Engineers Comments Regarding Surface Water Drainage

Application Reference:	AL/20/26/PL	Reviewer Reference:	ADC/EXT5/AF
Planning Officer:	Simon Davis	Date of Review:	29/05/2026
Site Name:	Land at West Barn Old Dairy Lane Norton PO20 3AF		
Application Description:	Demolition of existing tennis court and erection of a commercial building (within Use Class E(g), parking, landscaping and other associated works (resubmission following AL/107/25/PL). This application is a Departure from the Development Plan, may affect the character and appearance of the Norton Lane, Norton Conservation Area and is in CIL Zone 3 (Zero Rated) as other development.		
Assessment Number:	2

TYPICAL DETAILS OF SOAKAWAY USING
MODULAR UNITS

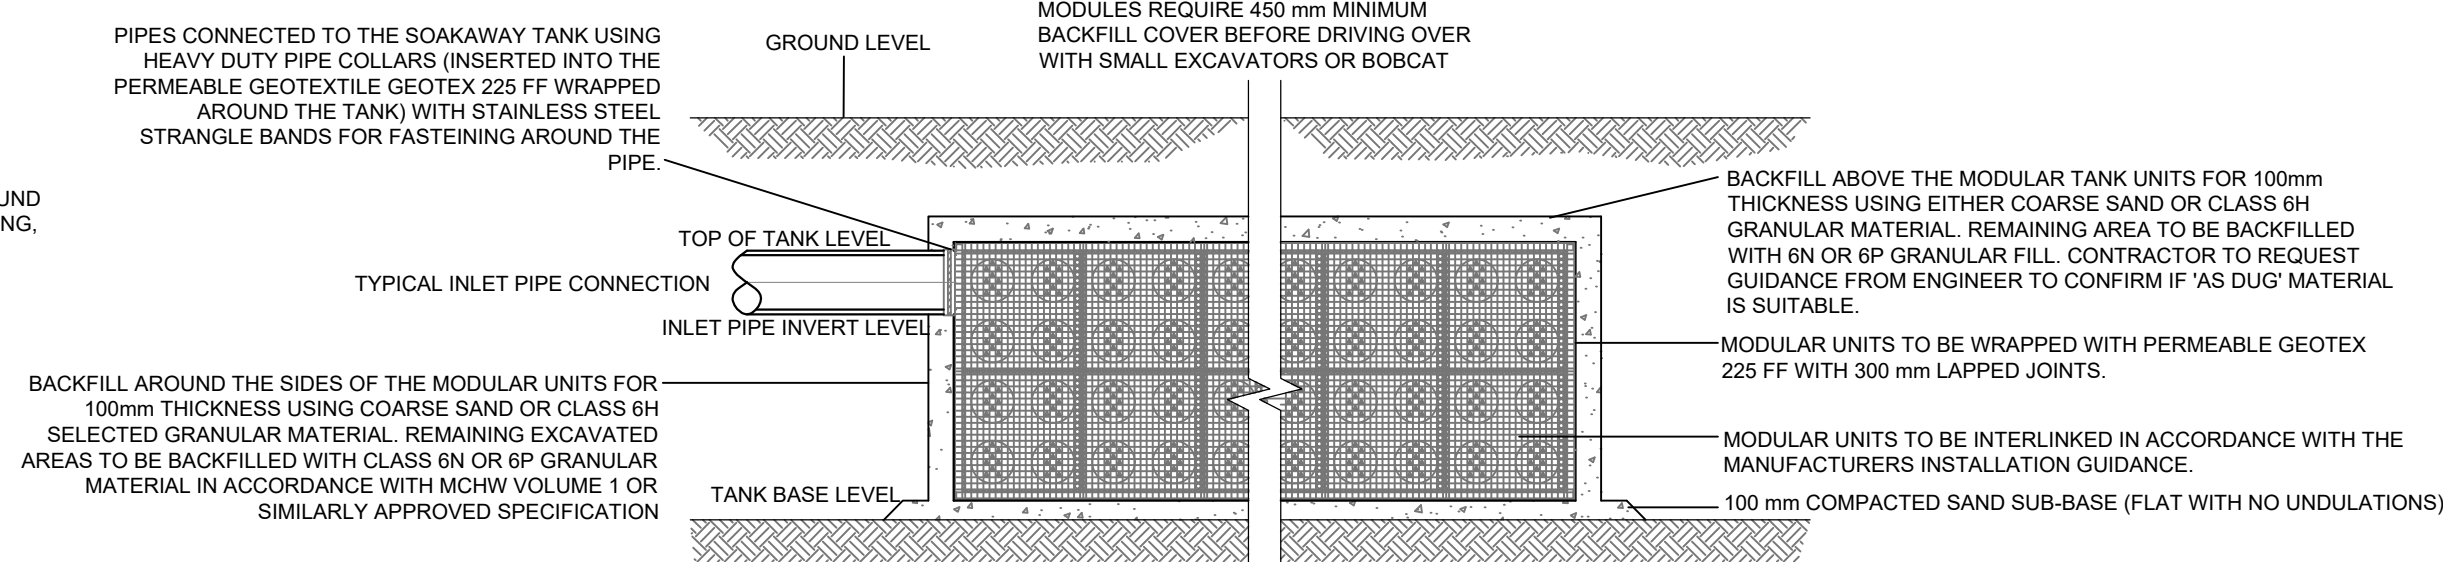
- 1.4. The proposed soakaway has been adjusted to be larger in plan and less deep to mitigate the risk of high ground water. The highest groundwater level for the current data is 2.2m below ground level. The proposed soakaway is approximately 0.8-0.9m below existing ground levels. The base therefore has a margin of buffer before the 1m vertical offset which is acceptable on a precautionary basis to mitigate the possibility that the annual peak had not been fully reached at the end of the groundwater monitoring.

- 1.5. However, the infiltration testing was carried out at 2.2m bgl with a starting head of 0.9m at the trial pit logs show different stratum (Harwich Formation) at that depth to the Head material at 1 metre depth. It therefore cannot be applied to the design infiltration rate as representative of the receiving subsoil at 0.8m bgl and above.

- 3.2. A suitable factor of safety is now applied to the soakaway but the infiltration coefficient is applied to the sides and the base, which is not in accordance with Arun DC design standards.

**PROPOSED DRAINAGE LAYOUT**  
SHEET 1 of 2

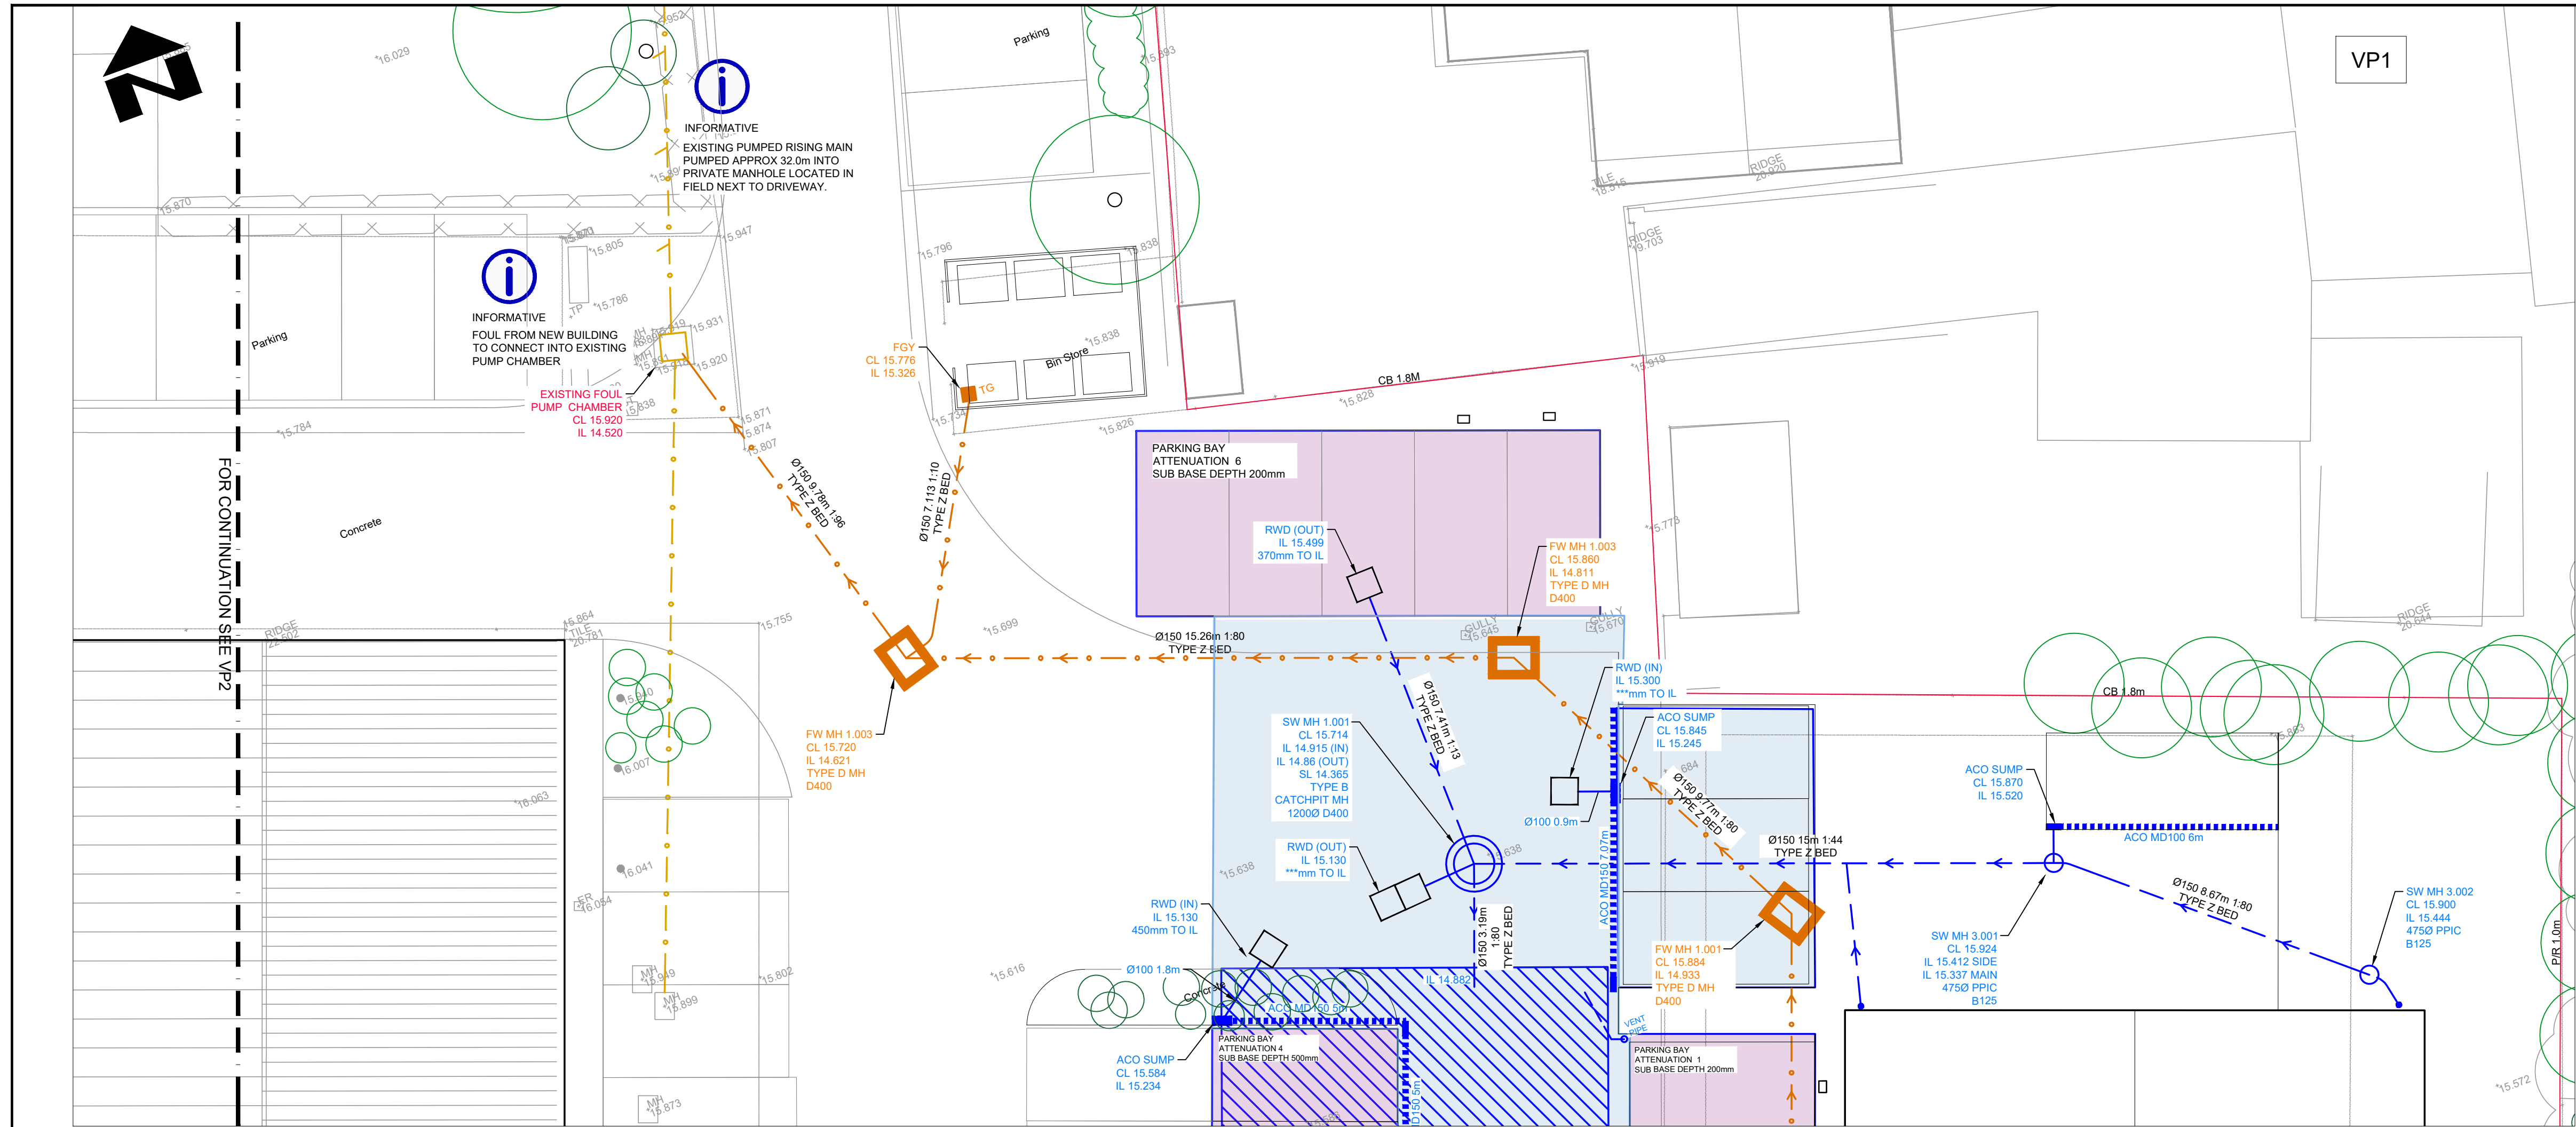
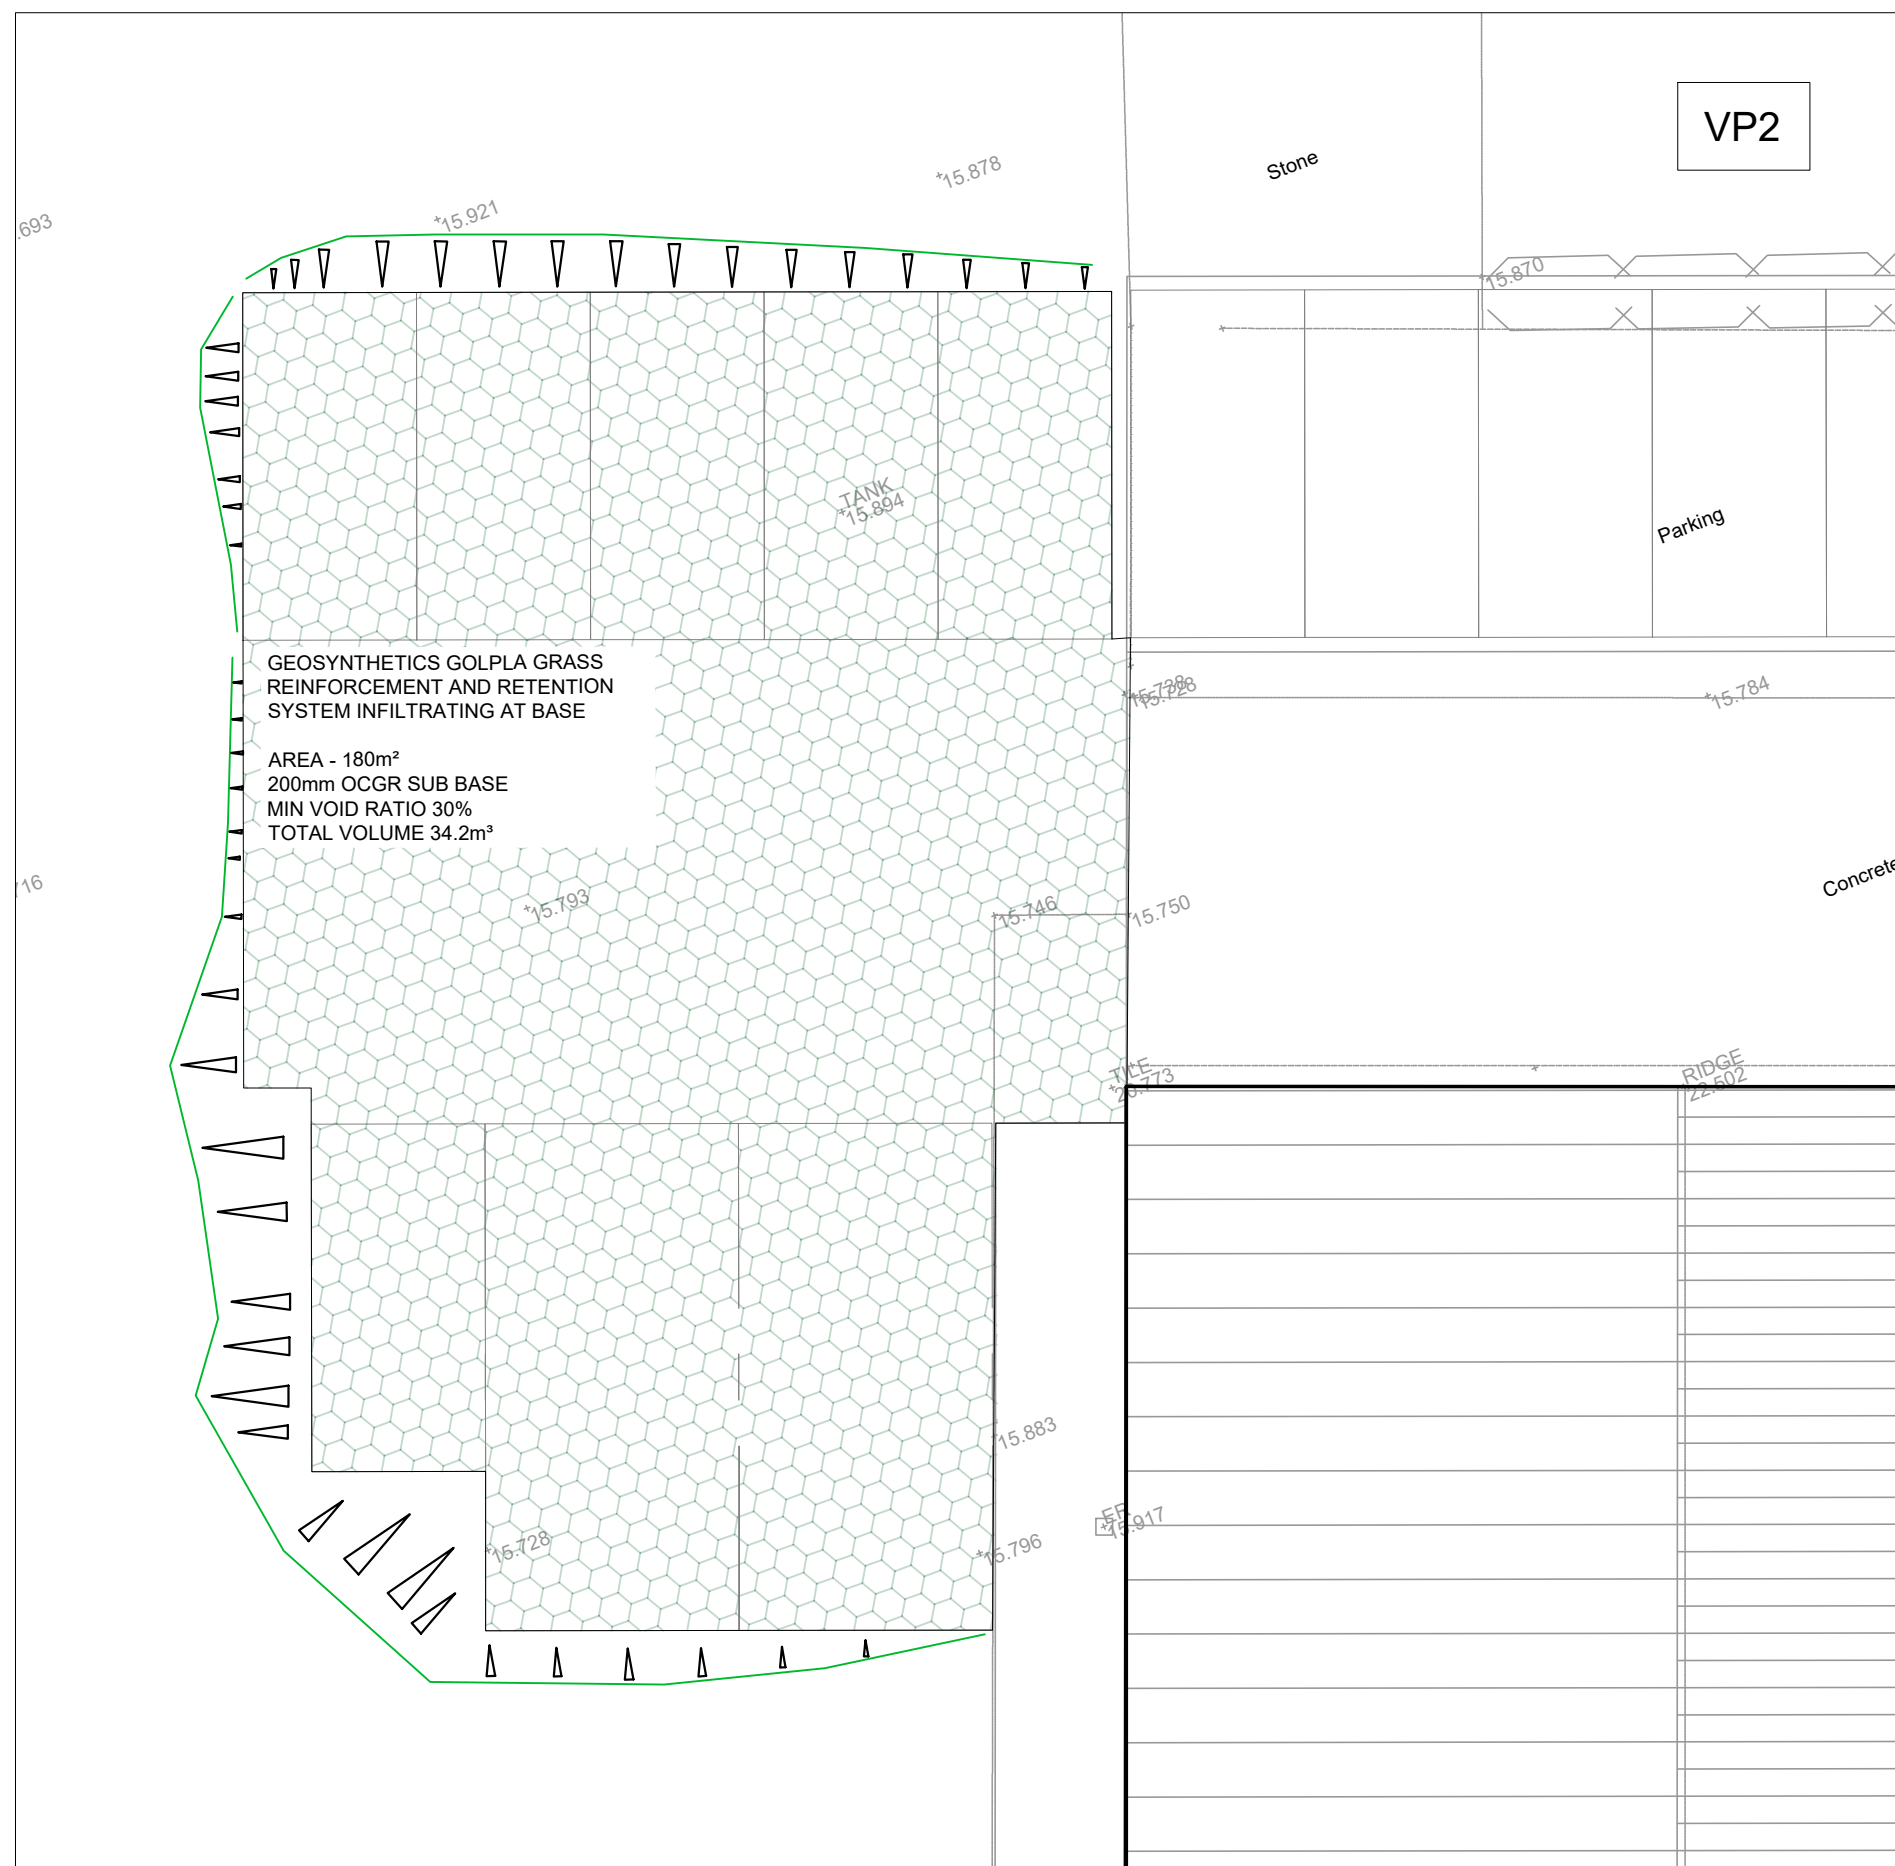
- 1.6. We are therefore not satisfied that the design is sufficiently robust and feasible. No alternative method of disposal is proposed should infiltration not be viable and the development is reliant upon the currently drainage strategy which must therefore be demonstrated to be viable at planning stage.

Chart 1 – Groundwater Records

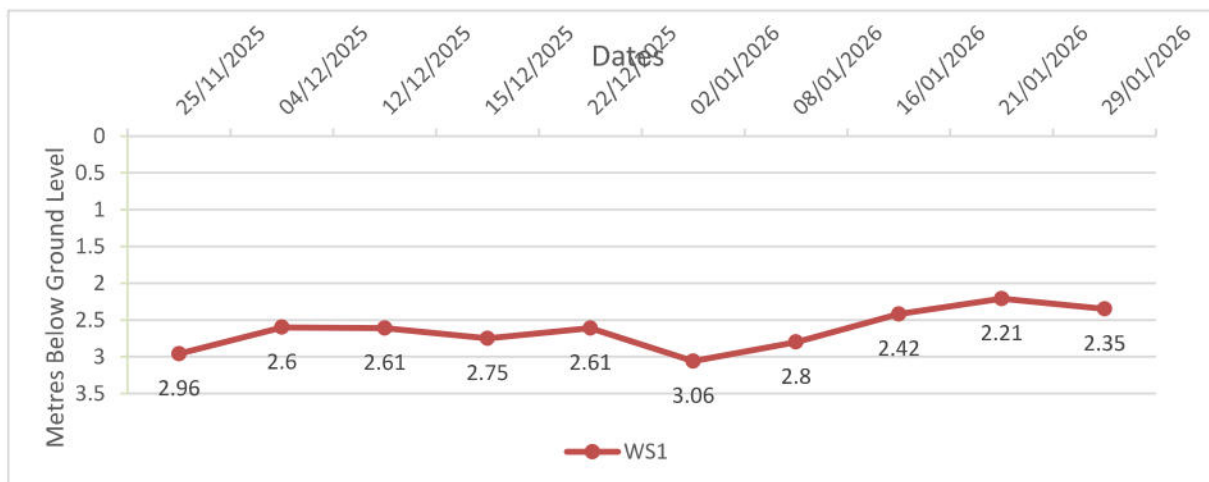
- 1.3. A ground investigation has been provided which includes winter groundwater monitoring up to the end of January 2026 and it is stated in the ground investigation report that groundwater levels are increasing up to a likely seasonal maximum in March. The current scope of the groundwater monitoring was previously agreed with ADC as part of pre-application enquiry.
